**Re: EXHIBITION OF STATE SIGNIFICANT DEVELOPMENT  
APPLICATION SSD-10388**

<b>PROPOSAL:</b>	<b>LIVERPOOL HOSPITAL MULTI-STOREY CARPARK</b>
<b>ADDRESS:</b>	<b>CAMPBELL STREET, LIVERPOOL HOSPITAL</b>

MASSING & BUILT FORM

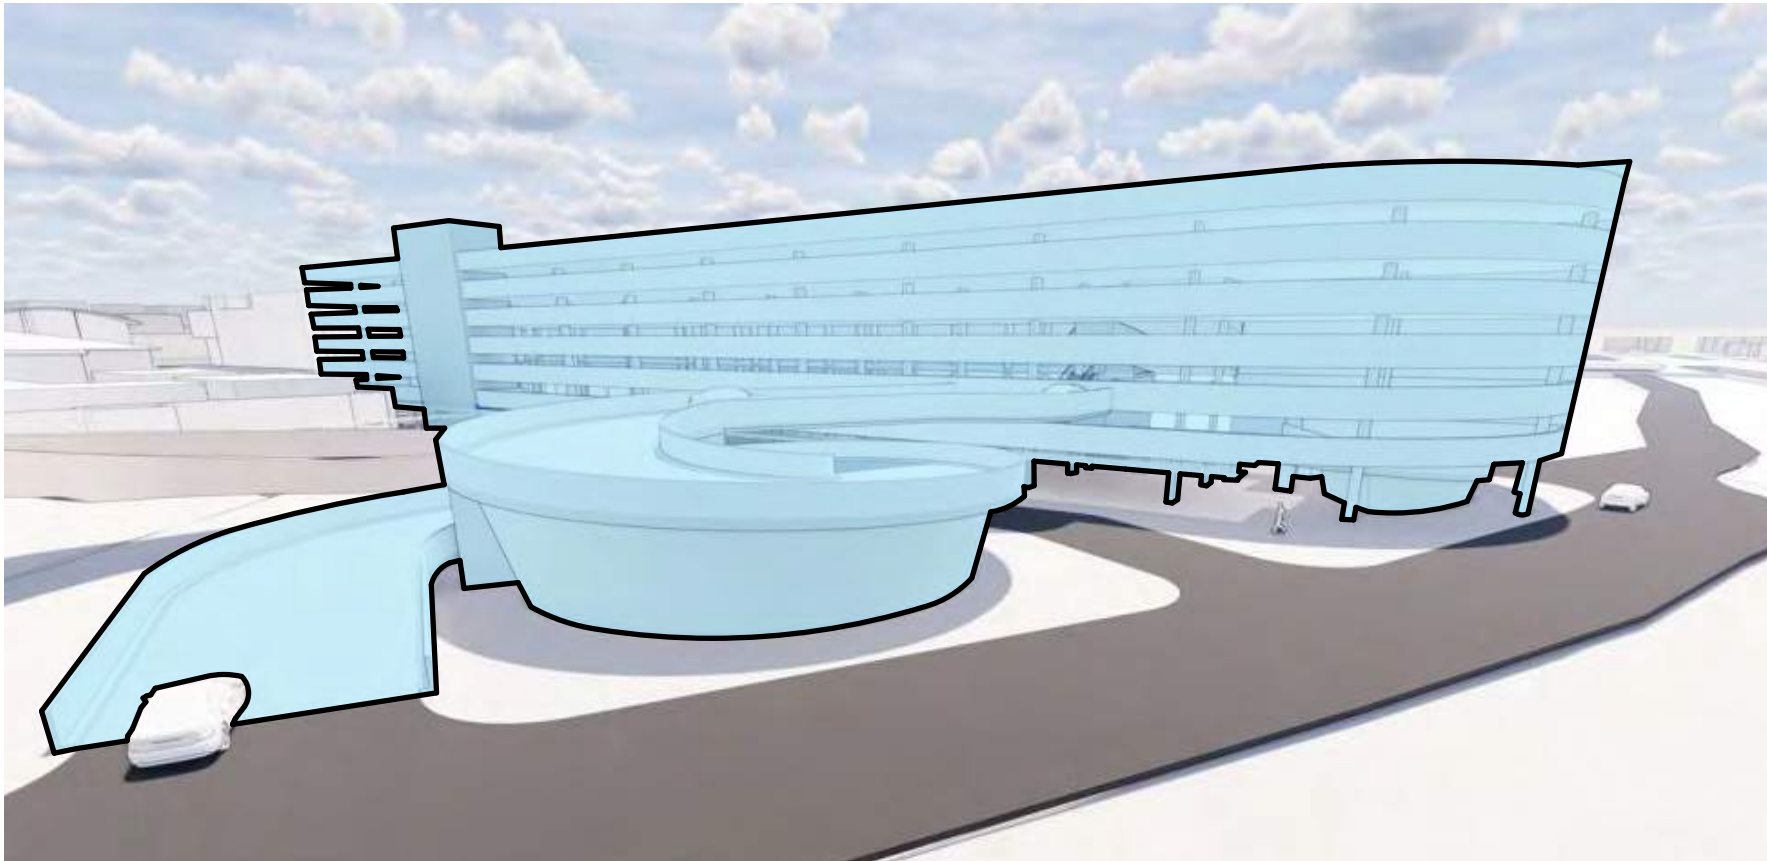
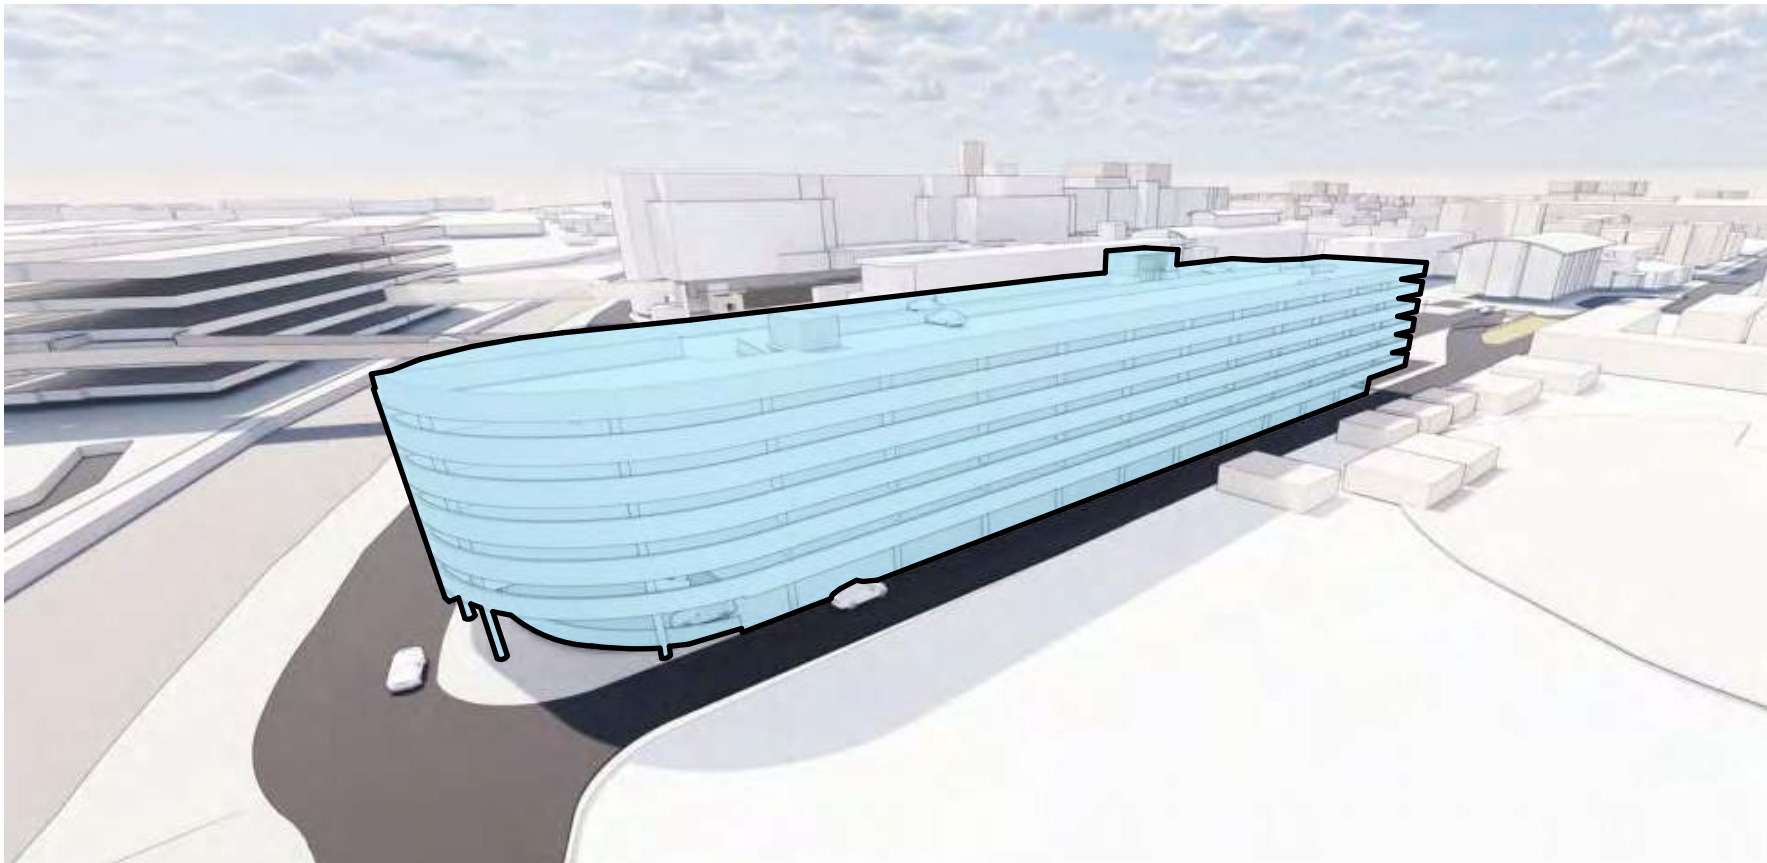
The proposal notes 2.8m expected floor-to-floor heights. Floor heights that would support adaptive reuse into habitable uses should be considered as part of a response to future-proofing.

- The proposed design of the multi-storey carpark must accommodate the capability of retrofitting the building for a different use in future. Consider increasing the floor to floor height to 3.5m minimum and ensure that the building is engineered to accommodate the flexibility/ease of retrofitting building elements for other uses in future.
- The use of sloping floors should be limited to the vehicular ramp areas only. This would ensure the capability/flexibility of retrofitting the building for other uses as required in future.
- Explore the potential of providing a landscape garden/amenity on the roof top level of the car park building. This would help increase the overall green cover within the city centre and help mitigate the adverse effects of urban heat island.

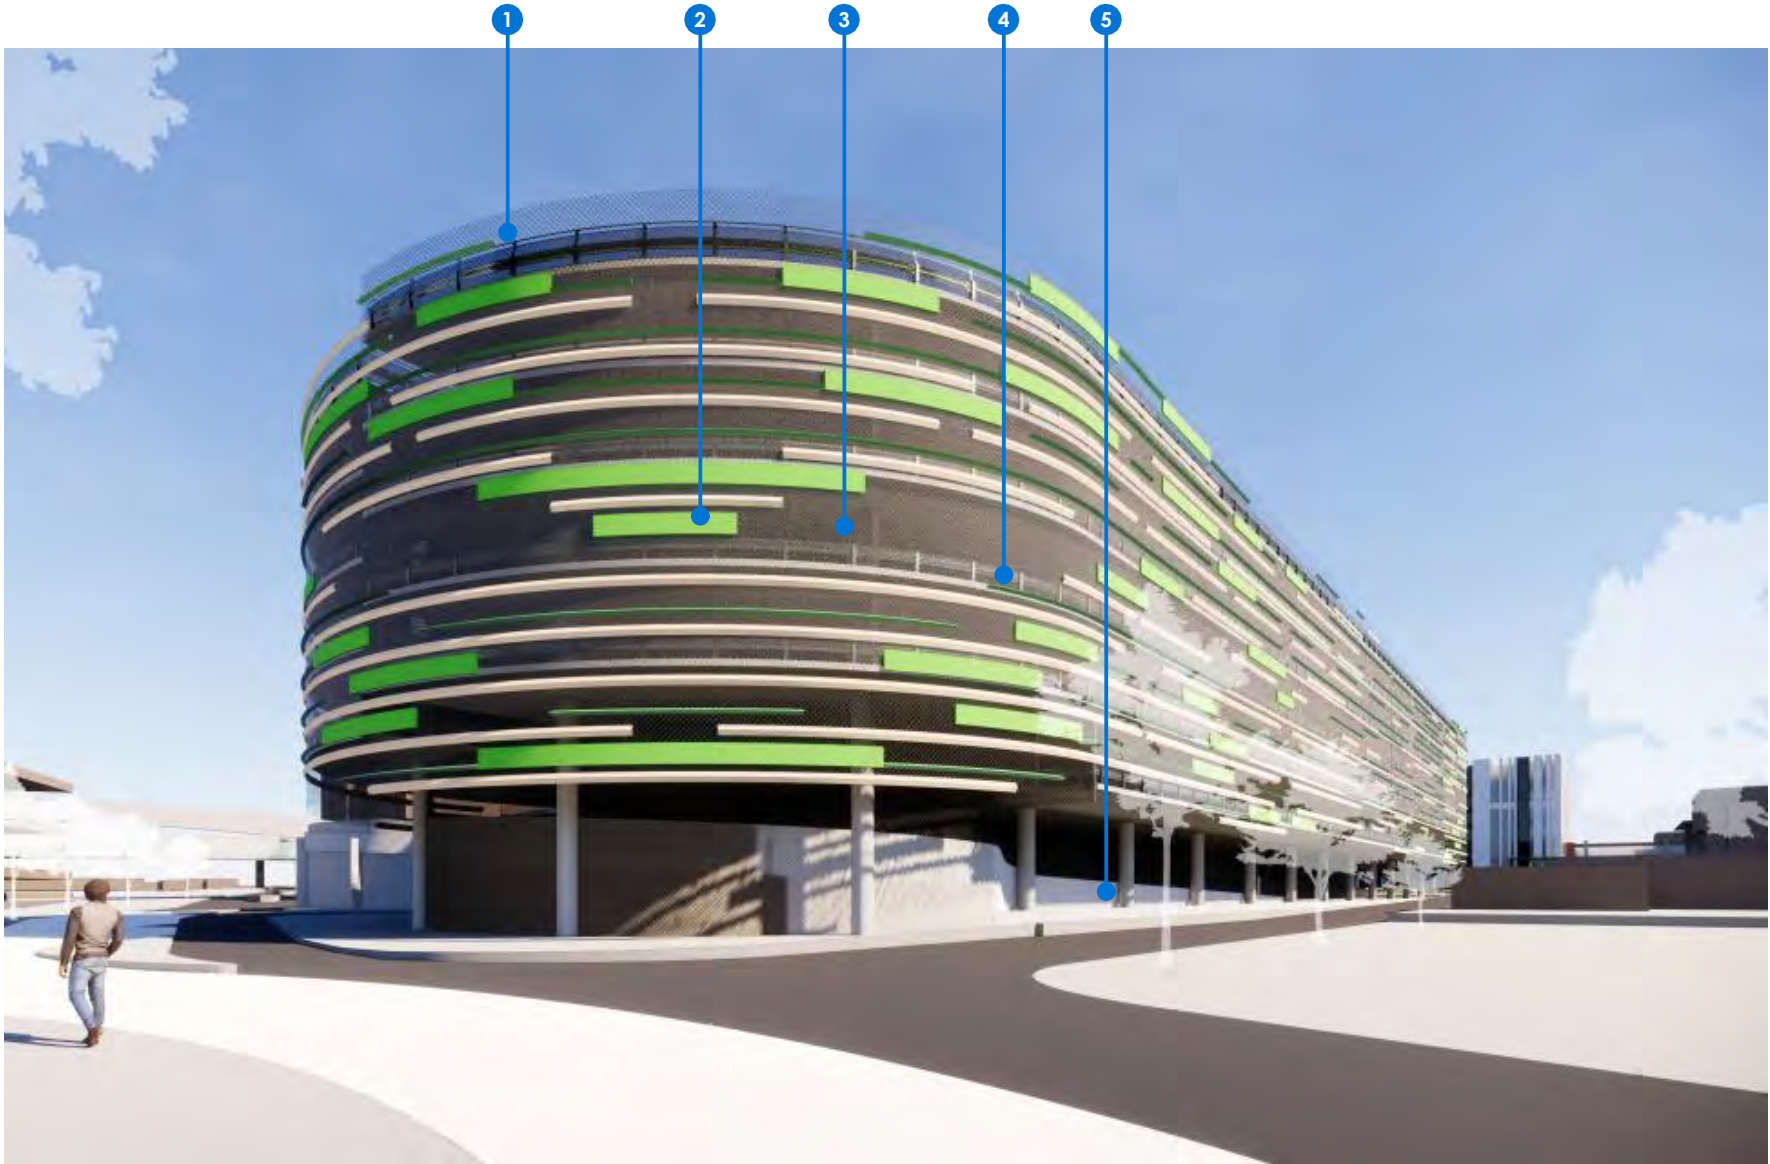
- Integrate climbing plant species in planters on each level of the car park. Include climbing trellis frame/mesh to the façade design to enable climbing plants to cover the façade and increase the visual amenity of the building.

LANDSCAPE STRATEGY

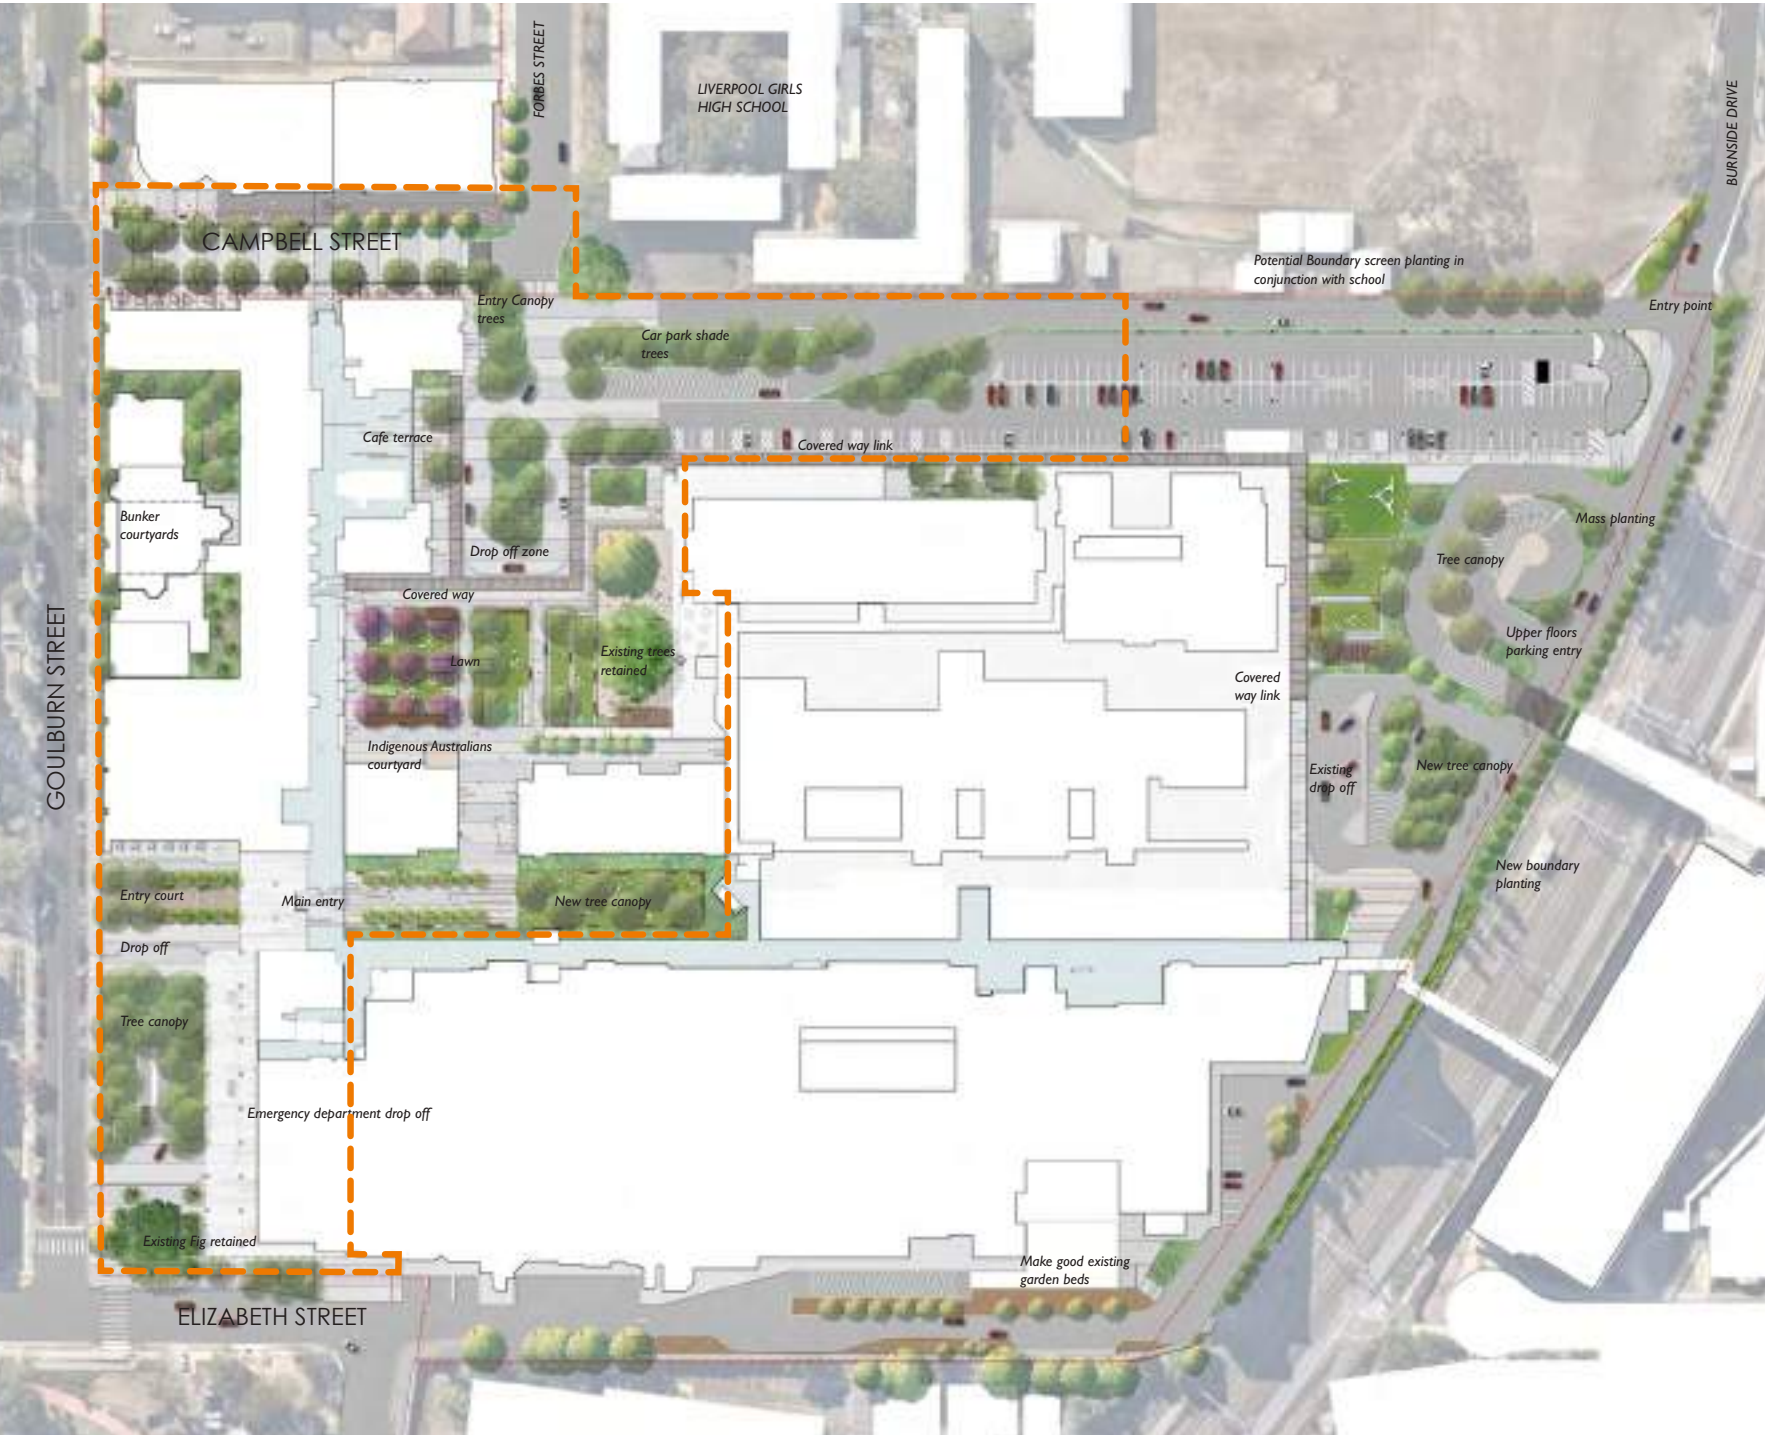
- The proposed southern courtyard will be shaded throughout the day, particularly during the winter months. Consider alternate tree species that will be suitable for these conditions and the microclimate within the courtyard.

- The landscape plans show climbing plant species to be grown on trellises, on the building façade, under the building overhang. Ensure that the species selected will be suitable for the conditions and microclimate of this location.
